DRB Project# 1002557 Subdivision Name Waggoman-Denison, Lot 18A, Blk:

APPLICATION NO. 03DRB-00472	PROJECT NO. 1002557
PROJECT NAME E.J. WALTON / WAGGOMAN-DENISON ADDN.	
EPC APPLICATION NO.	
APPLICANT / AGENT JAMES FINDLEY	PHONE NO. 379-7008
ZONE ATLAS PAGE K-20	Submitted 3/24/03

ONE STOP COMMENT FORM LOG

PLAT OF
 LOT 18-A, BLOCK 8,
 "WAGGOMAN-DENISON ADDITION"
 CITY OF ALBUQUERQUE, BERNALILLO COUNTY
 STATE OF NEW MEXICO
 JANUARY 2003

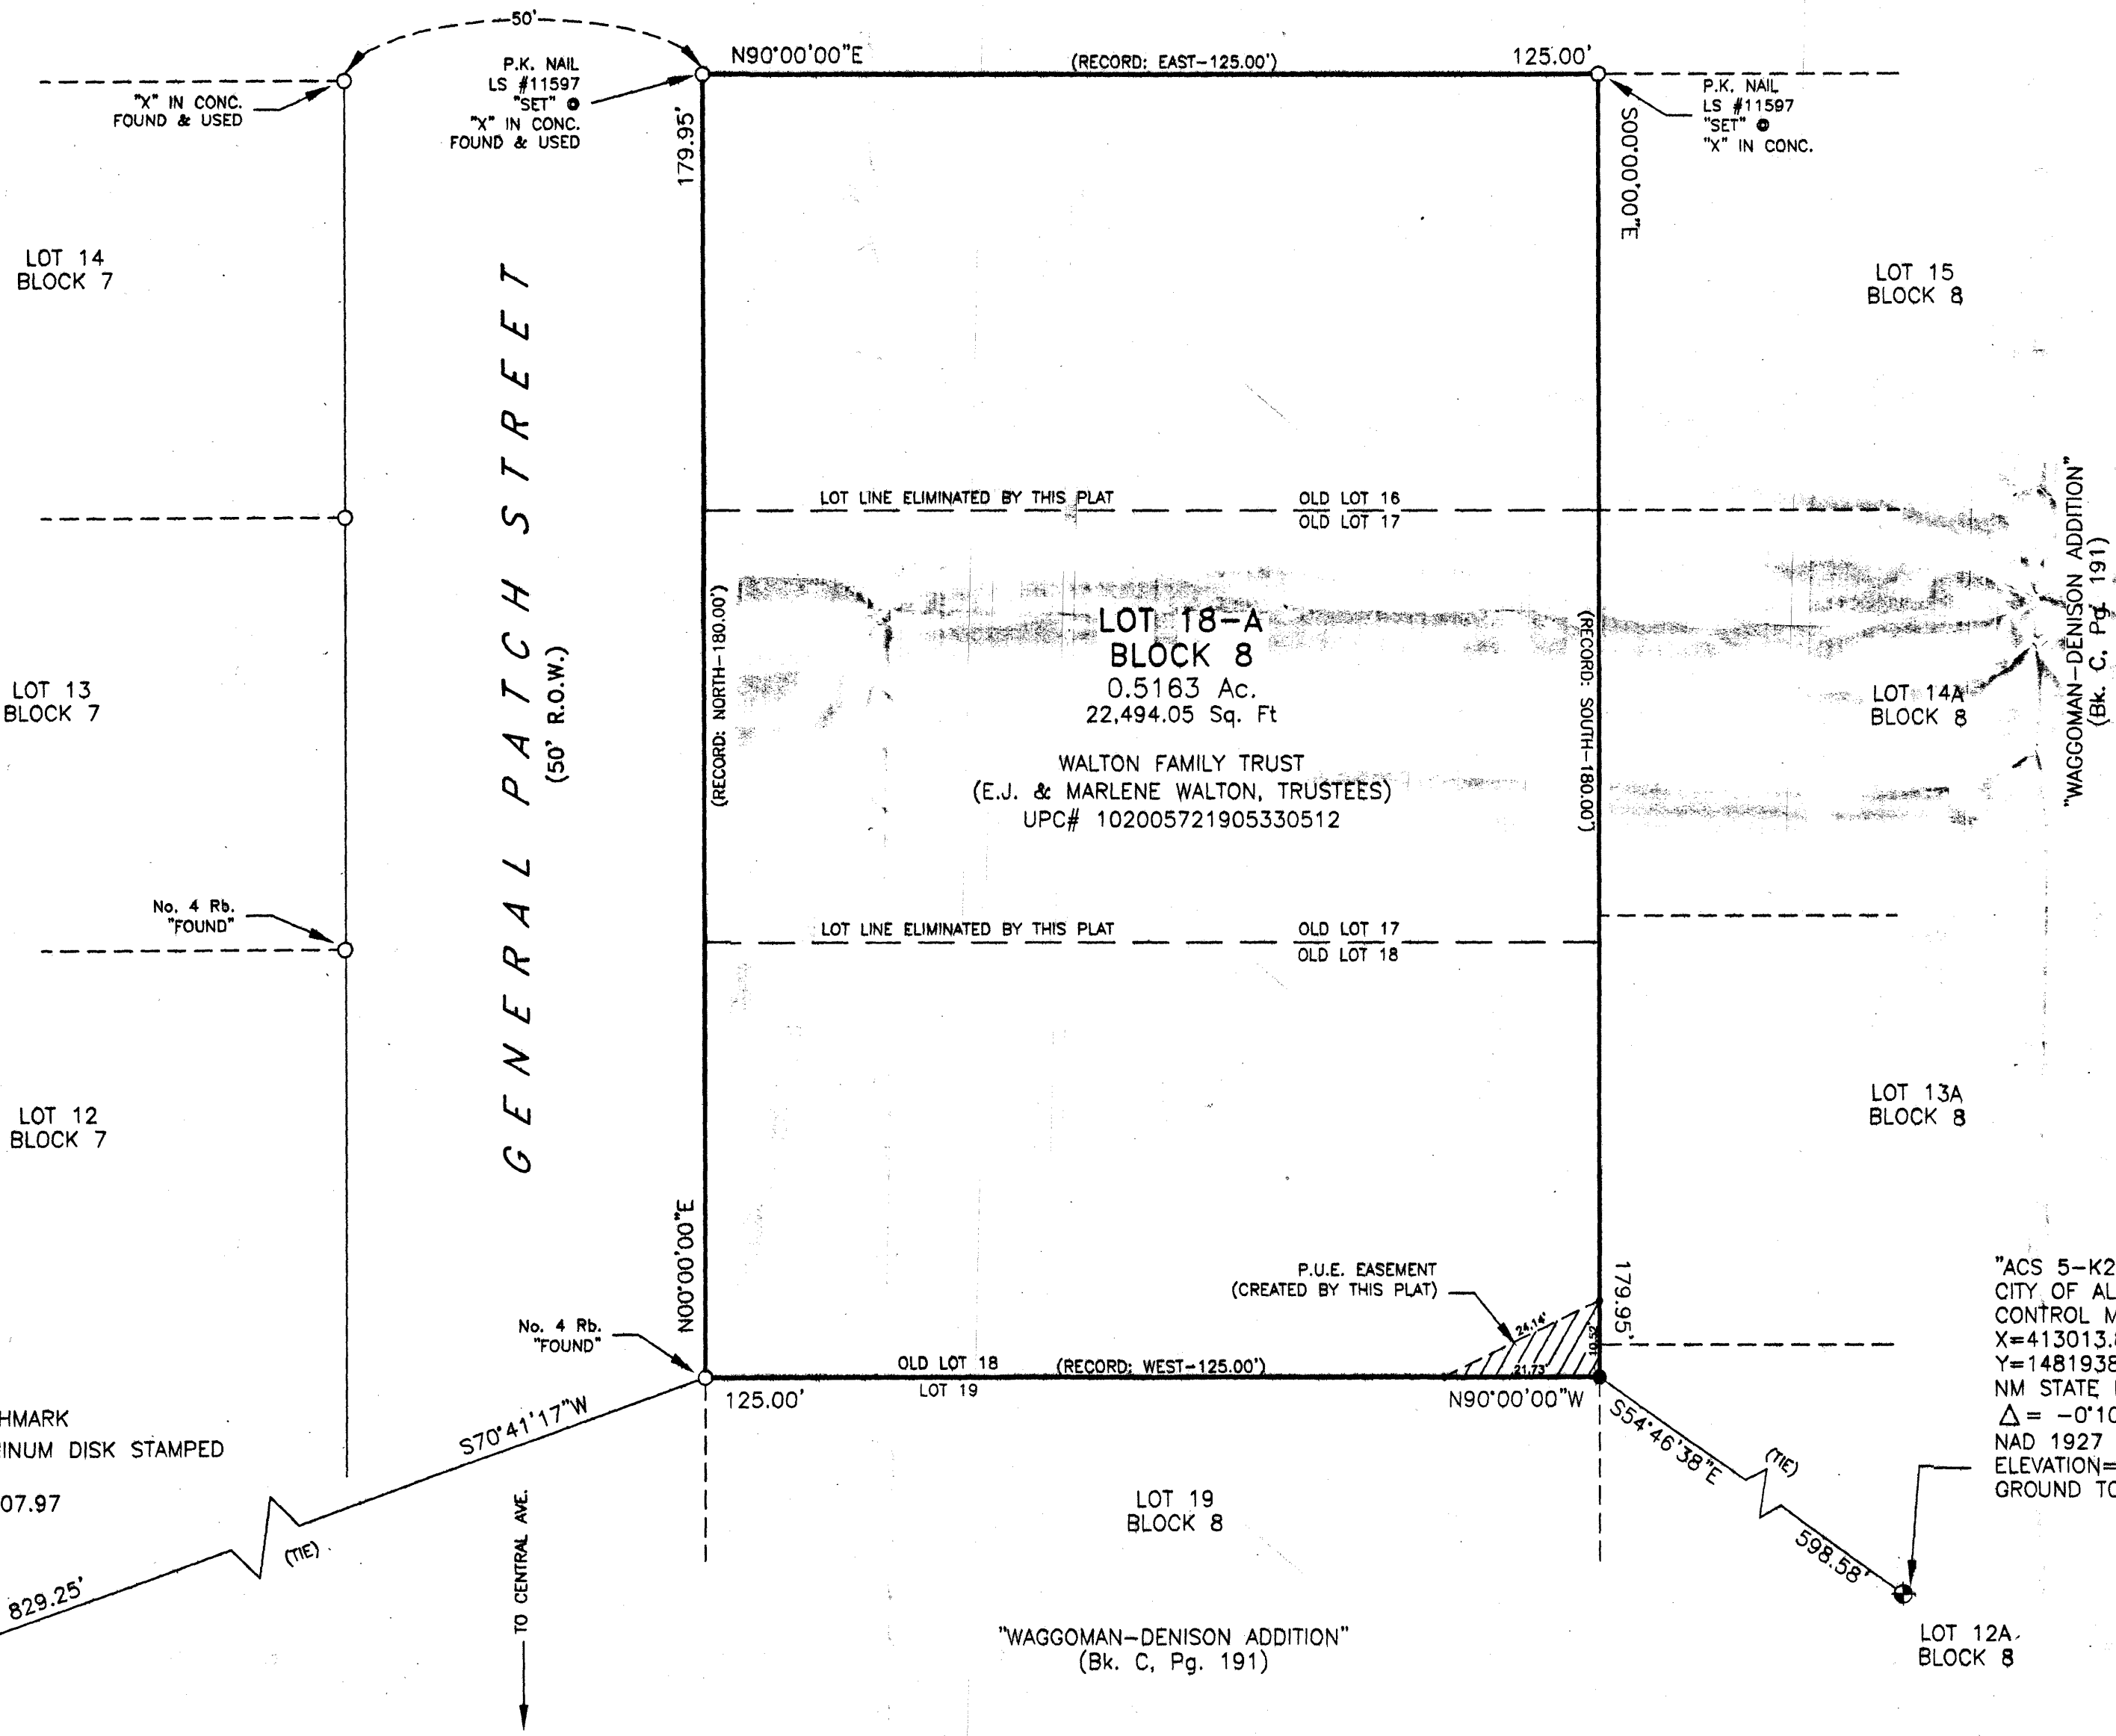
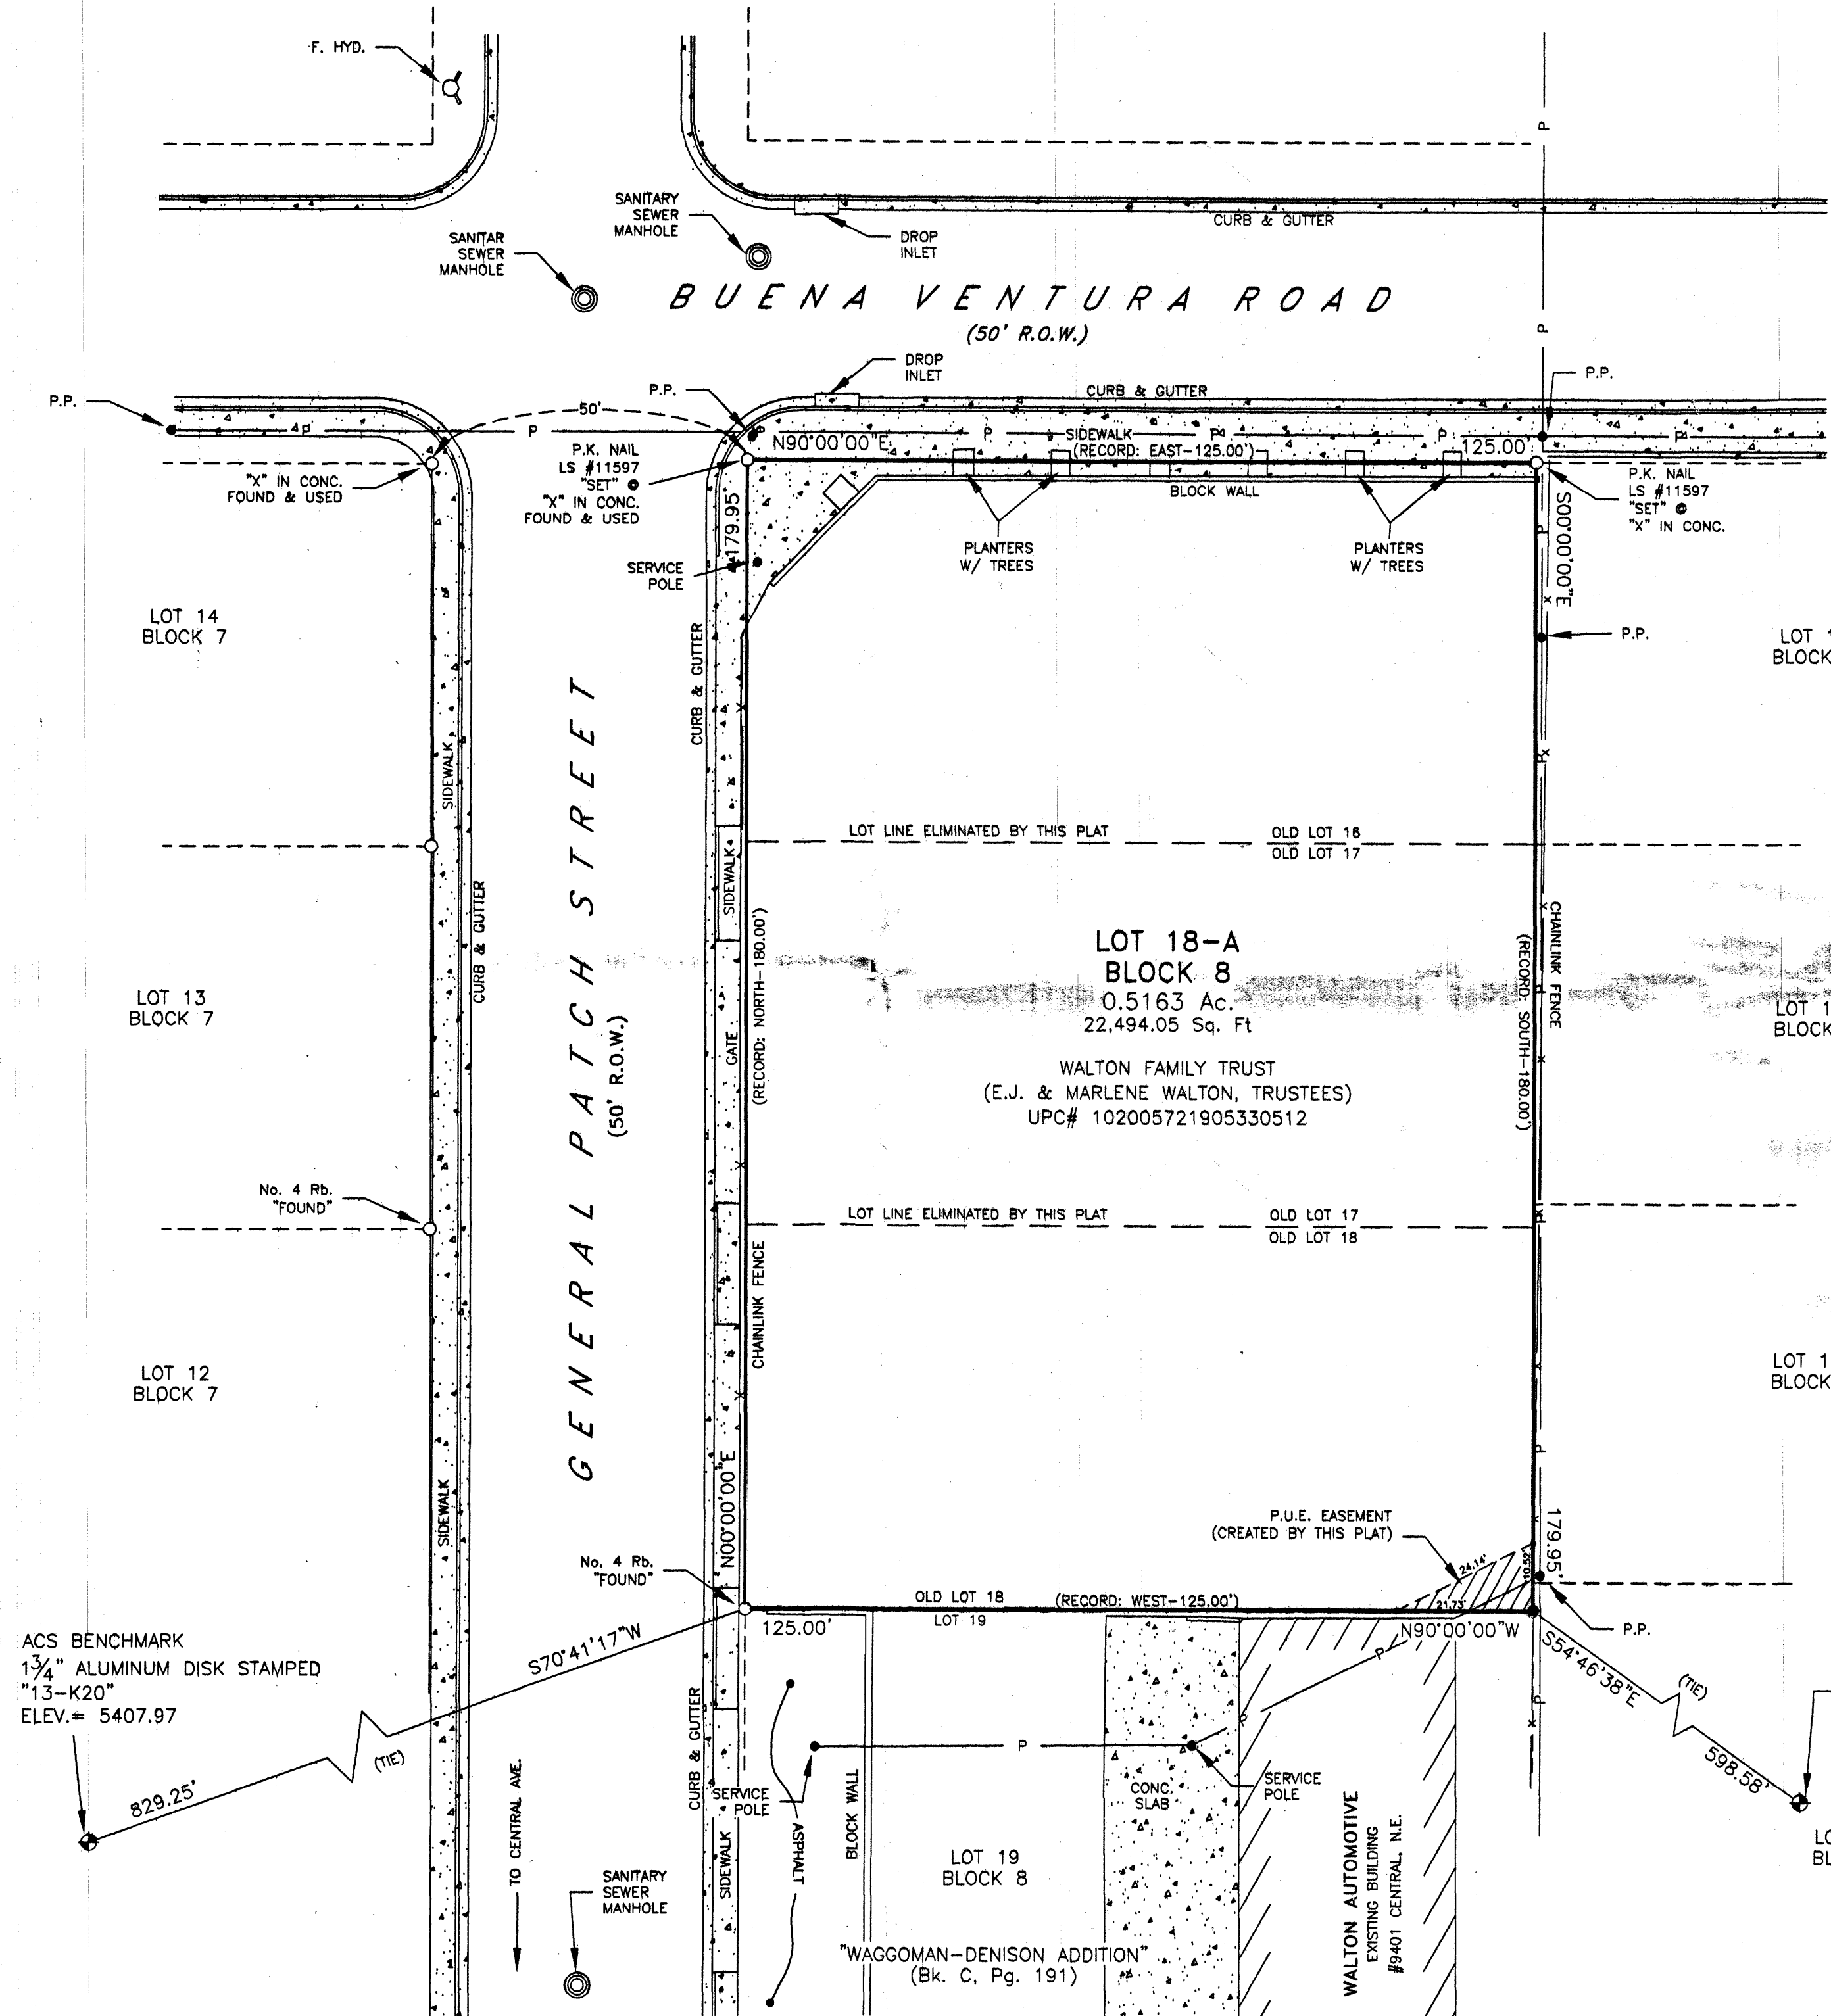
COMMENTS:
- Dedicate 9' from face of curb on General Patch and 20' RADIUS at Intersection
